APPLICATION NO: BR/190/17/PL

Site Address: 76 London Road Bognor Regis PO21
1DD

Description of Two & part three storey rear extension

Works: for an additional 4 No. dwellings.

Proposed Ground Floor Plan

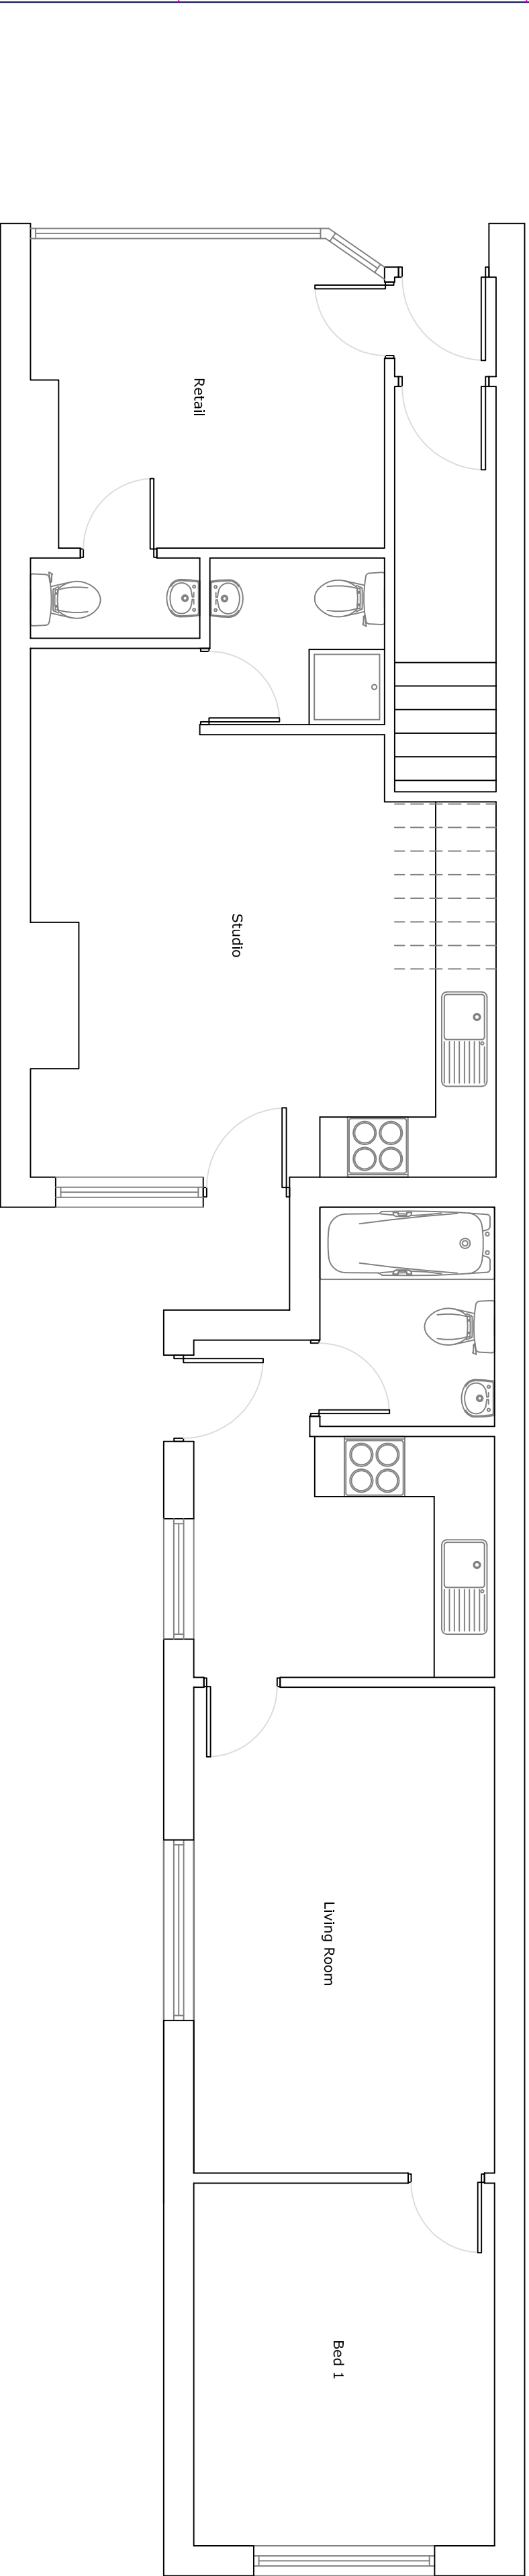
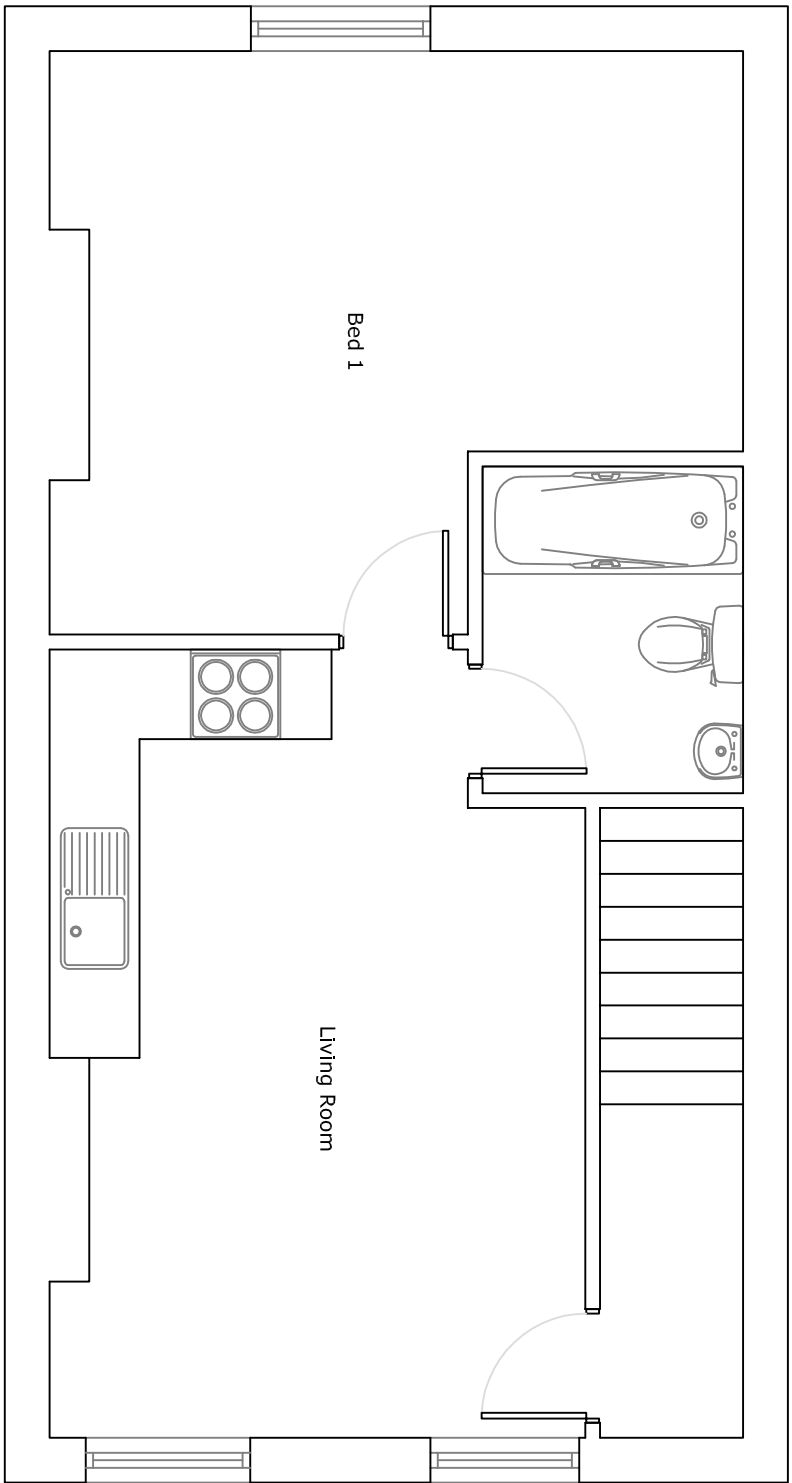
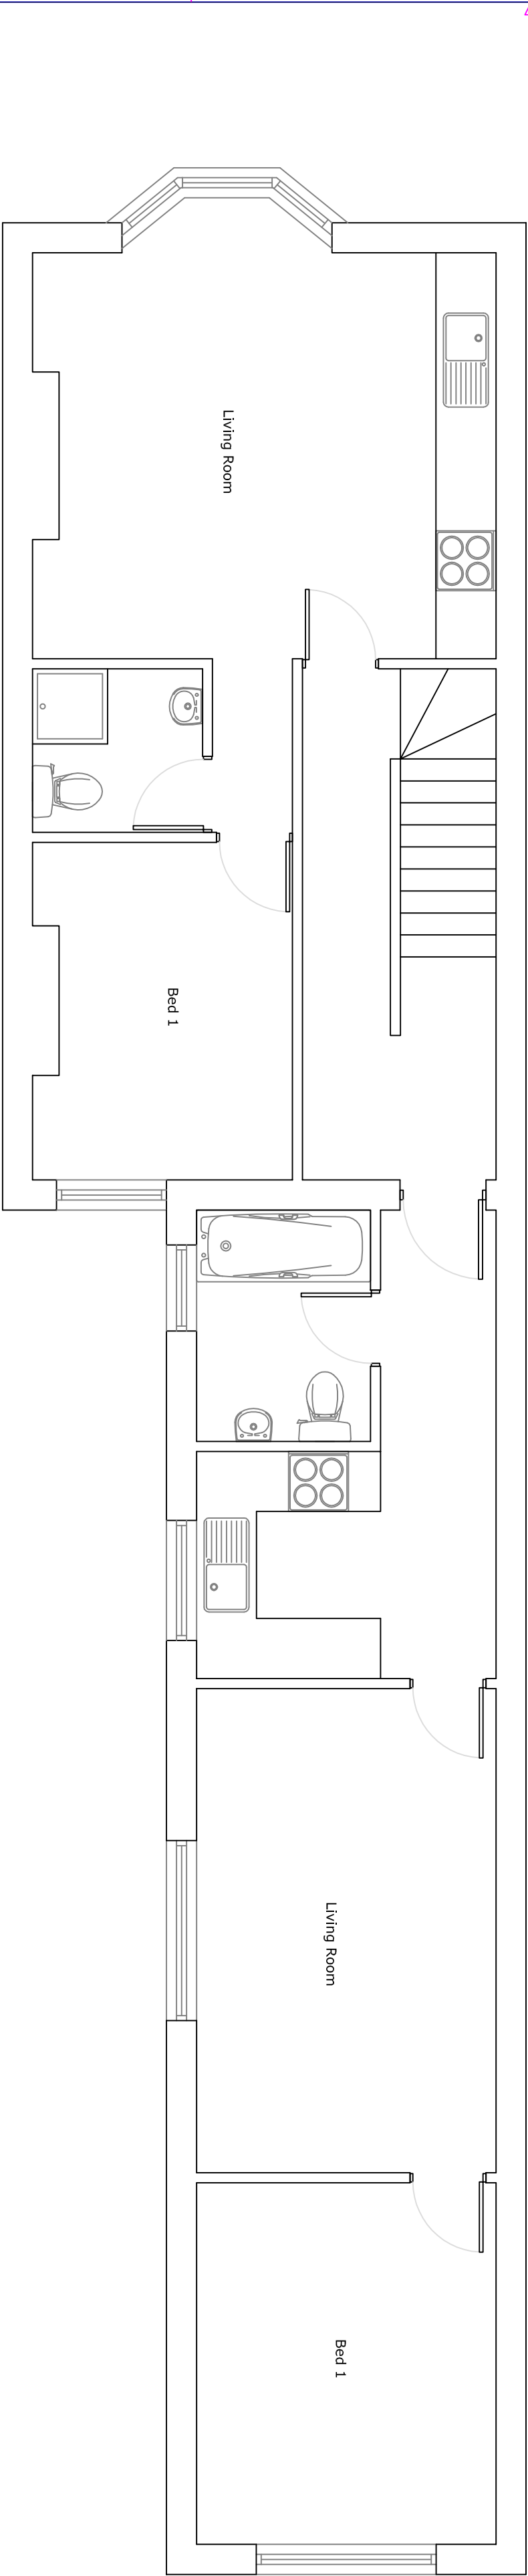
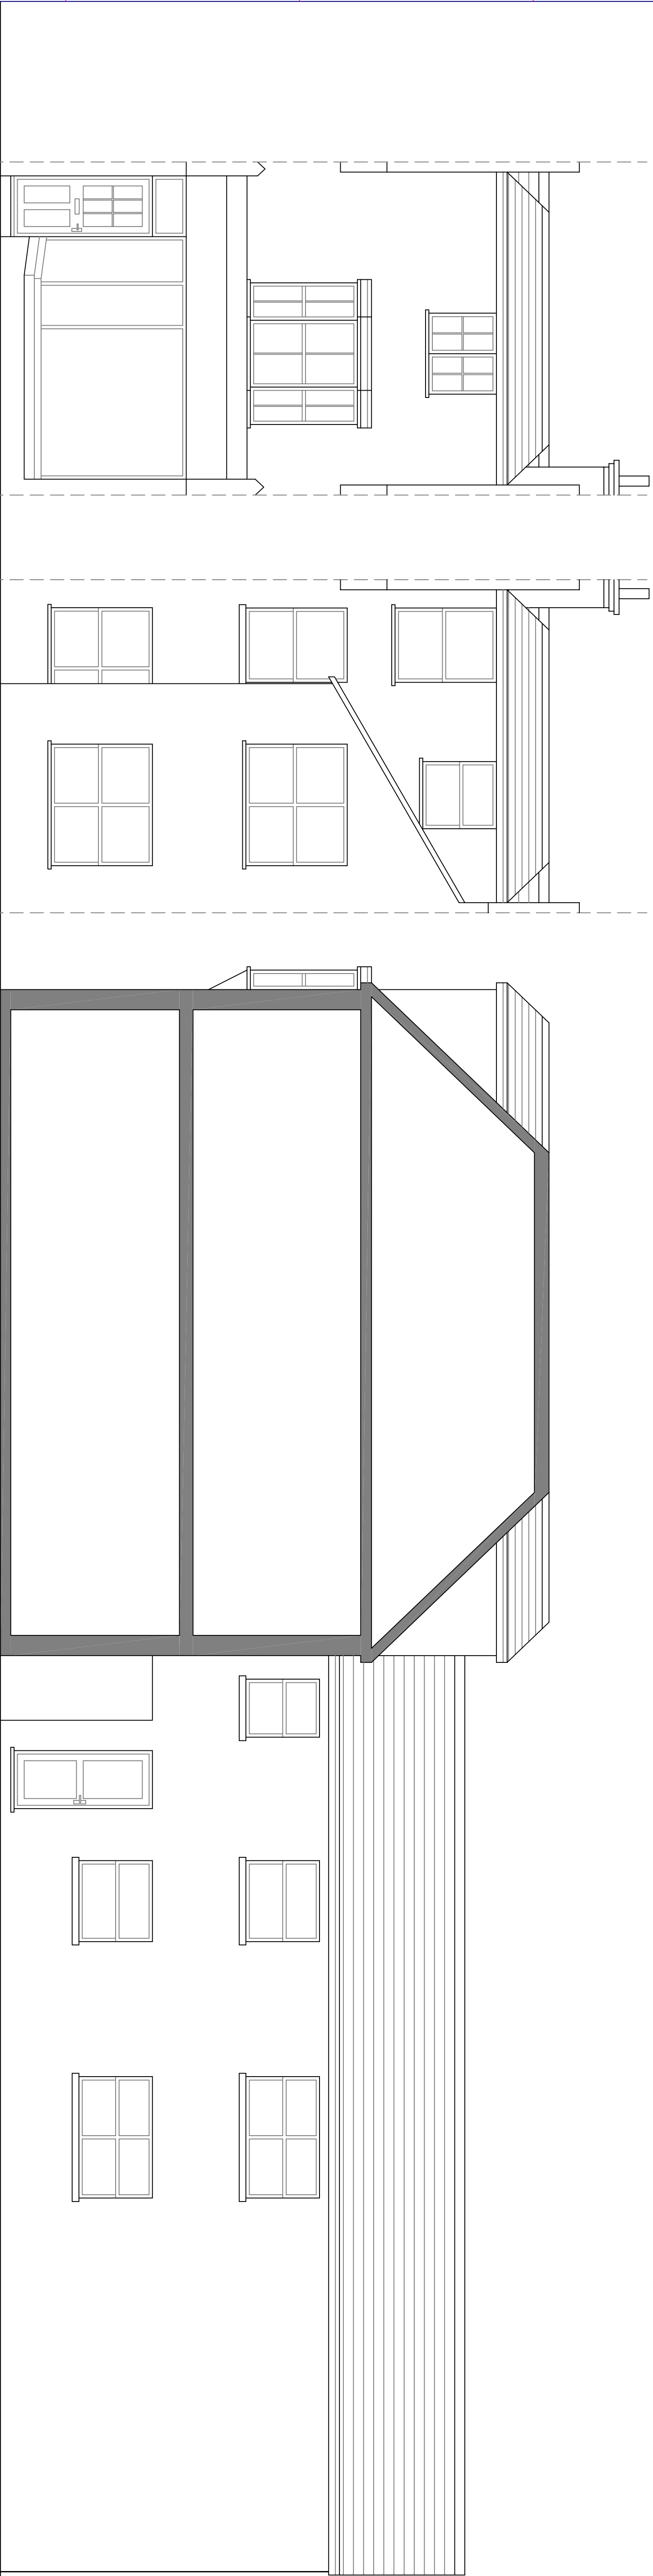
Economic Development would object to this application. The reduction in retail space would likely impact the viability of this unit as a retail space. There is no storage space or service area, meaning that all goods storage/food preparation etc would have to be in the same space as the sales area. Whilst many companies now operate with less stock than previously some storage space would be required.
